RMS Reference: SYD12/00236/16 and SYD17/00918/07  
DPE Ref: SSD 5175 MOD 4 and SSD 8588 MOD 2

**MODIFICATION TO THE EASTERN CREEK BUSINESS HUB  
ROOTY HILL ROAD SOUTH, ROOTY HILL**

To address this issue Roads and Maritime requested the electronic SIDRA files for SSD 5175 MOD 4 and SSD 8588 MOD 2 for review. The SIDRA files have been reviewed by Roads and Maritime and the following comments are offered:

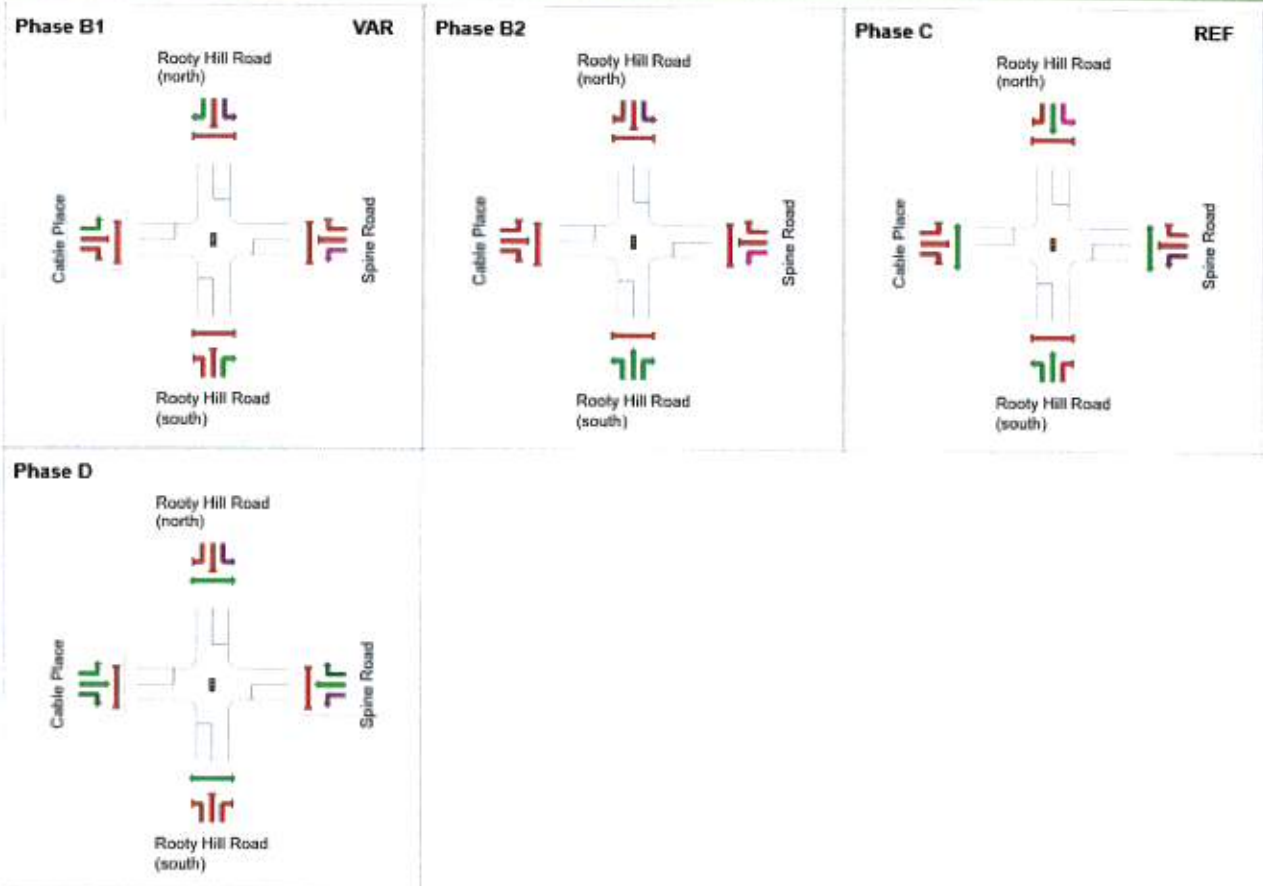
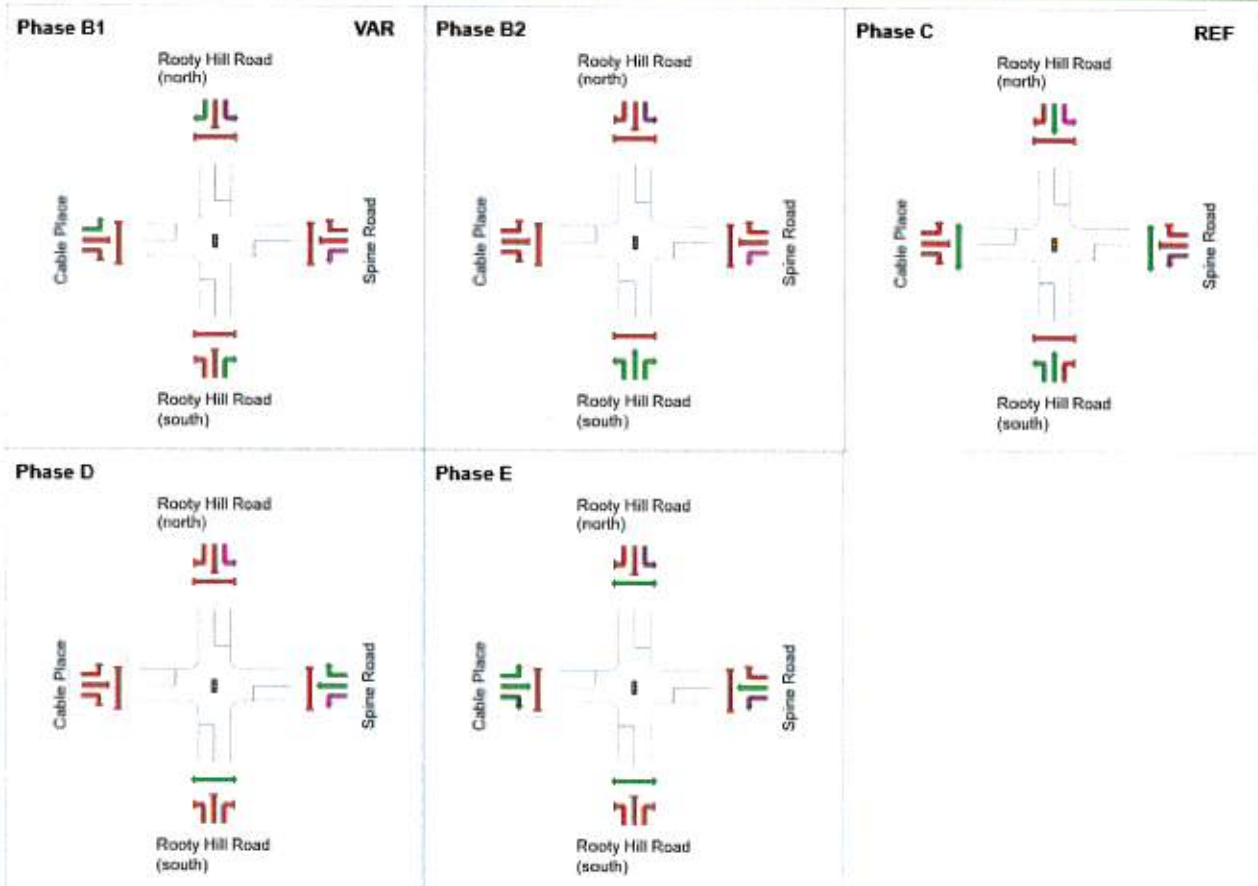
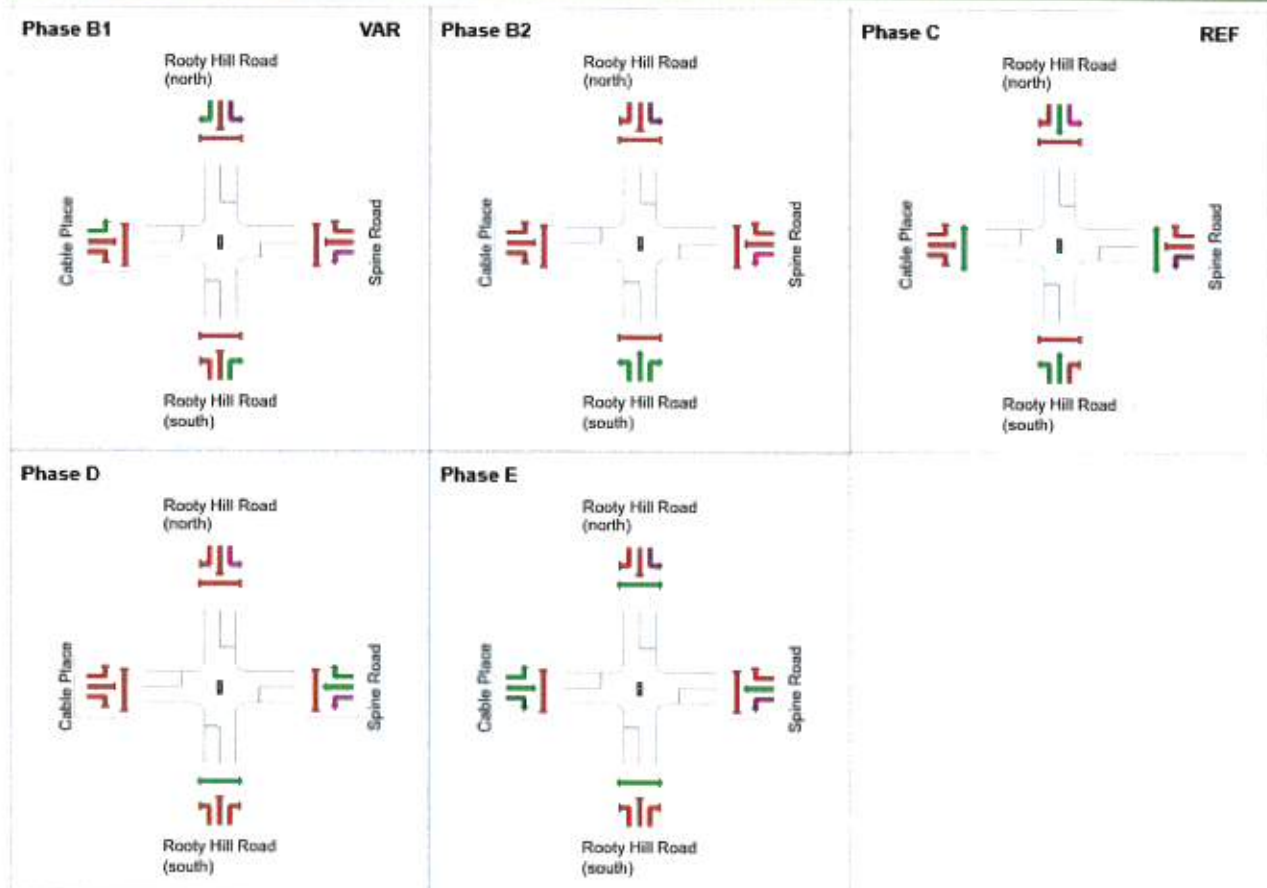
1. The PM and SAT models show the cycle time at 80s and 100s. Cycle time of the new intersection will usually be set to 120-130 max cycle time. By updating the cycle times to the usual standards the LOS should improve. This change is to be made and resubmitted.
2. Changing the right turn arrangements from the development onto Rooty Hill Road South from one right turn movement to a dual right turn would also improve the LOS. Amended modelling is to be provided that assesses the possibility of the installation of a dual right turn exiting the proposed development.
3. Swept path plans are to be provided that assesses the movement of a dual right turn onto Rooty Hill Road South.

The comments above are to be amended and the revised modelling (electronic SIDRA files and SIDRA output tables) and swept path plan are to be submitted for review.
